**Consultation Response from KC,
Trees**

2024/92062 Former Staff Car Park, Land of Willow Lane, Birkby, Huddersfield, HD1 5EB

Change of use of land for siting of a secure self-storage facility (maximum of 93 movable storage containers) (within a Conservation Area)

Date Responded: 08/08/2024

PROPOSED SITE PLAN

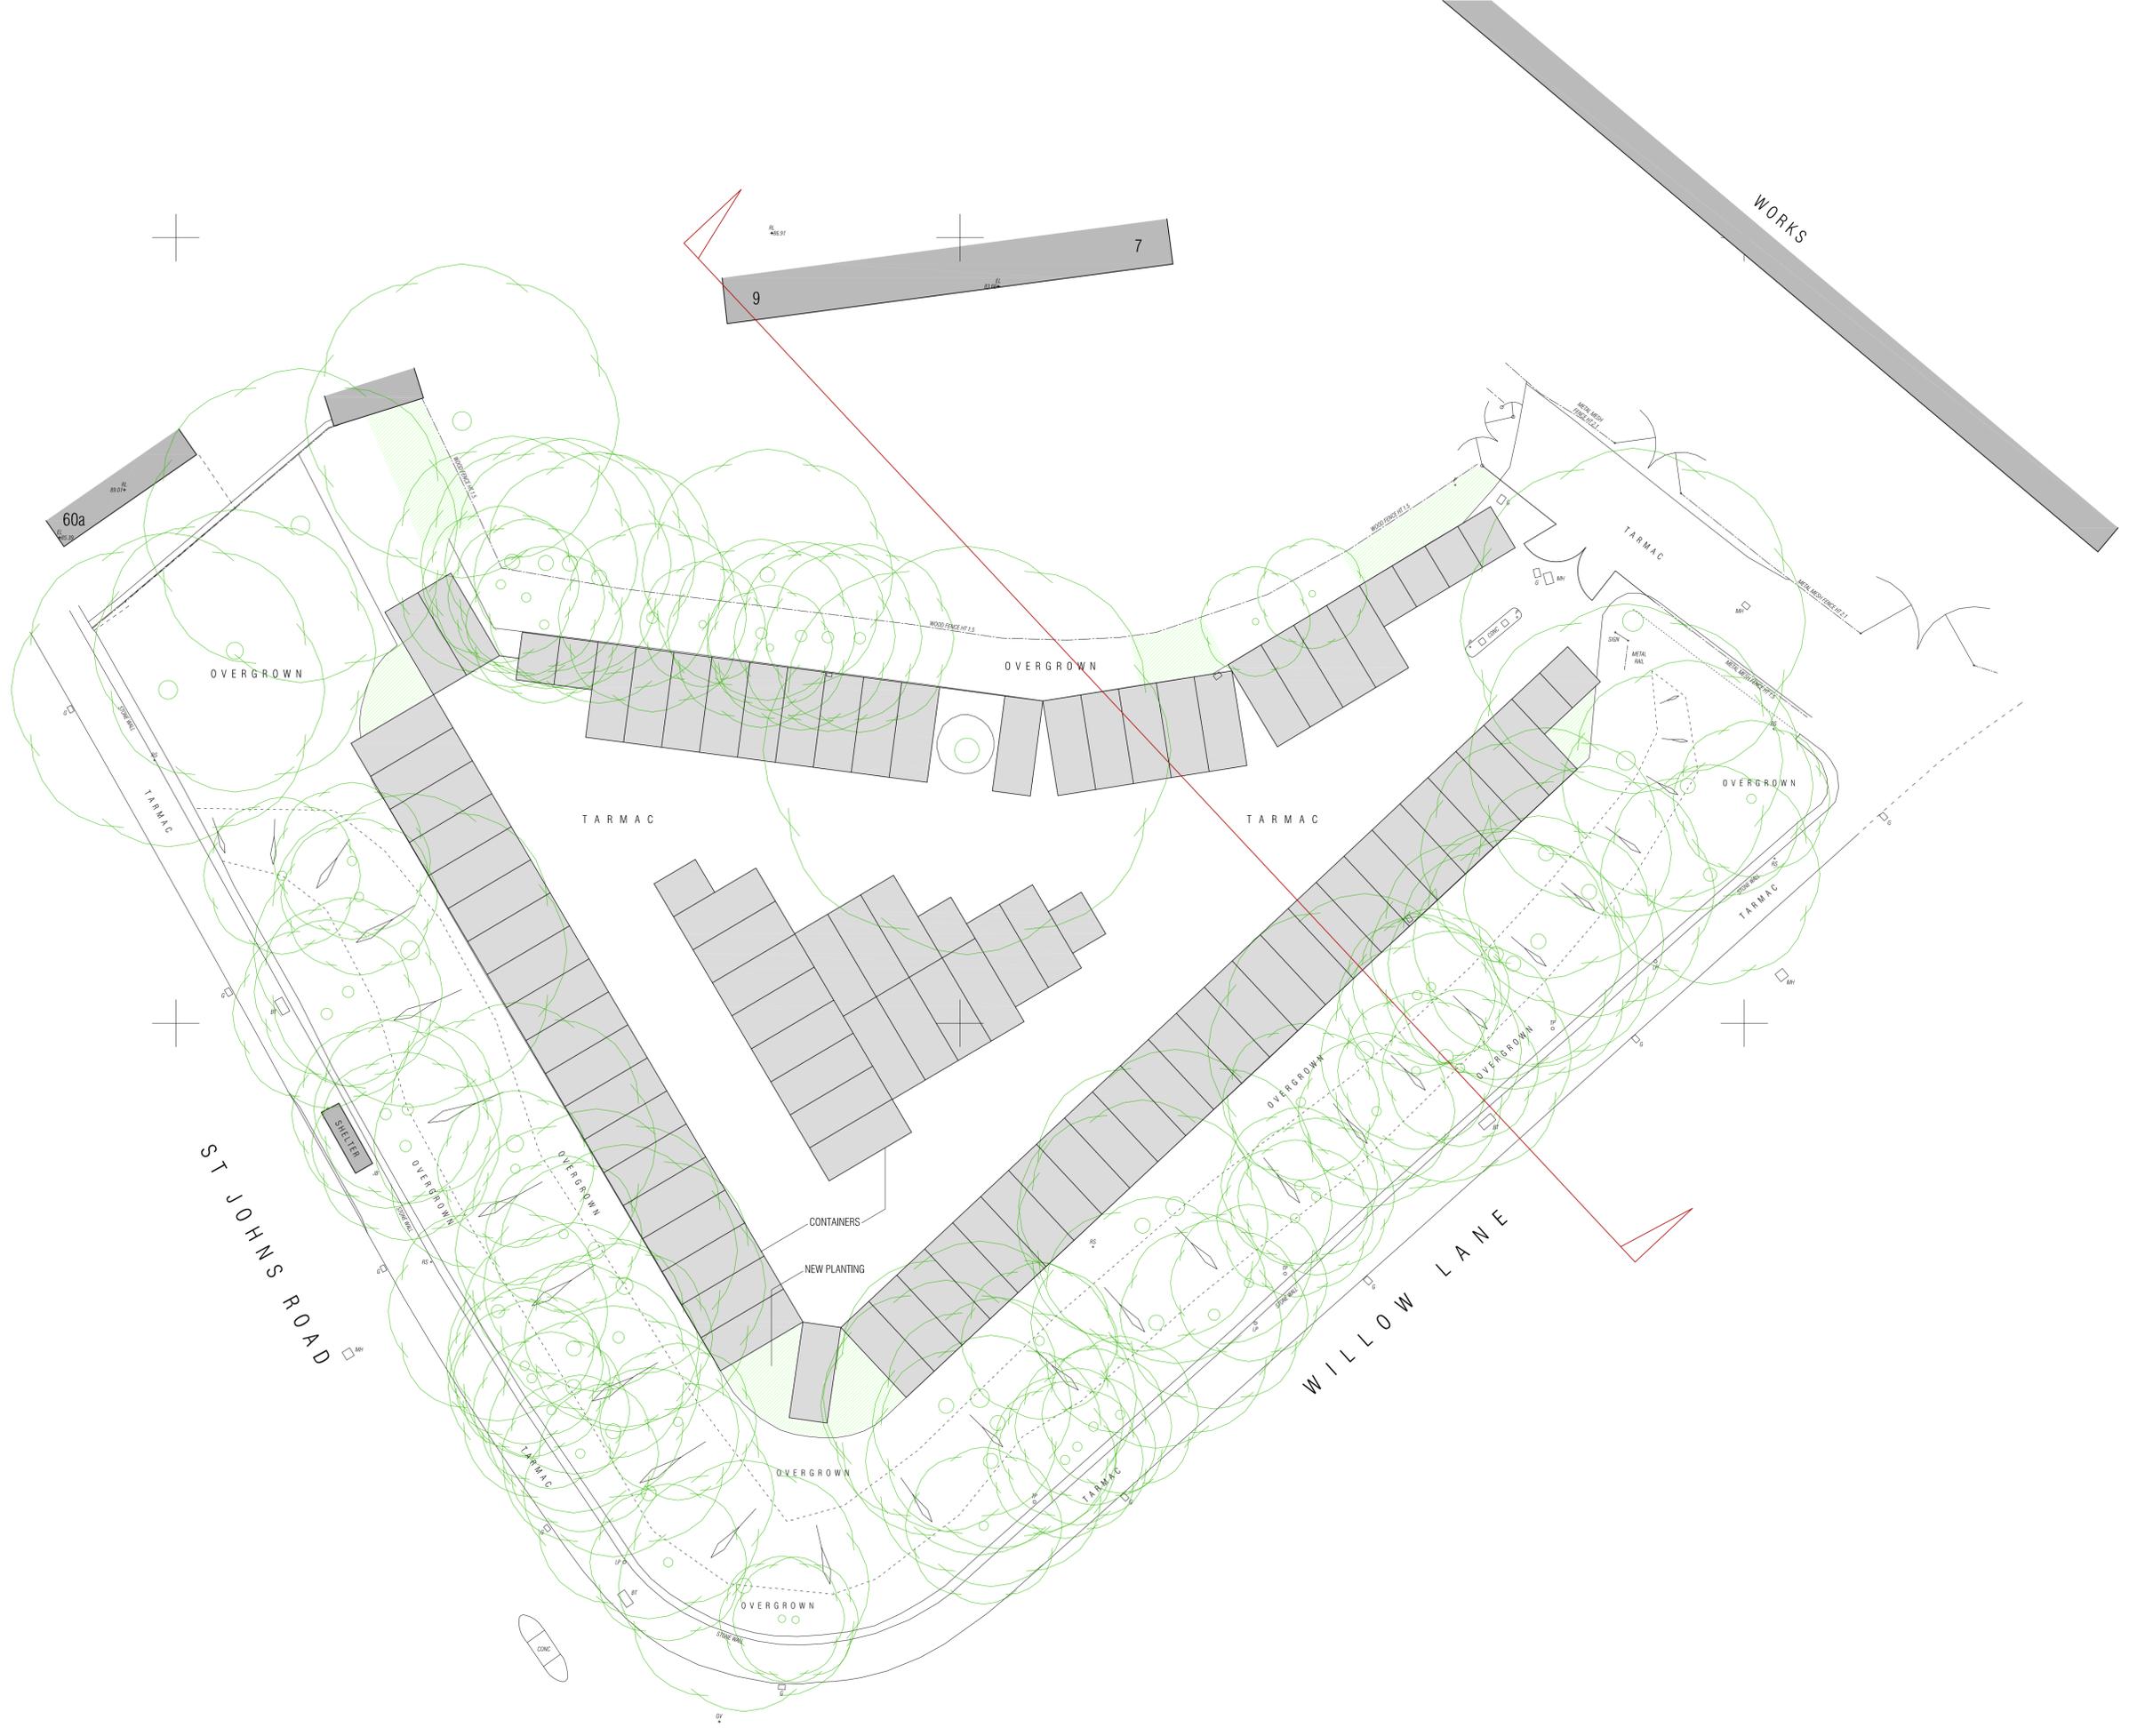
Due to the close proximity of the trees to the existing tarmac, there is likely to be a large number of roots present underneath. If the existing tarmac is being retained then there is unlikely to be any significant impact on the surrounding trees. However, if the proposal is to remove the existing tarmac and lay new tarmac there is likely to be a large scale impact on all trees. Further clarification is needed with regard to how the tarmac is to be laid.

There has been no Arboricultural Impact Assessment submitted with the proposals which makes it impossible to know the extent of the impact there will be on the trees. Also due to the proximity of the trees to the development area an Arboricultural Method Statement and protection plan would be required to ensure the safety of retained trees during construction should the plans be approved.

There is a holding objection until an AIA is submitted and clarification of the method of hardstanding to be used. The proposal conflicts with adopted Kirklees local plan policy 33 and 24 (i).
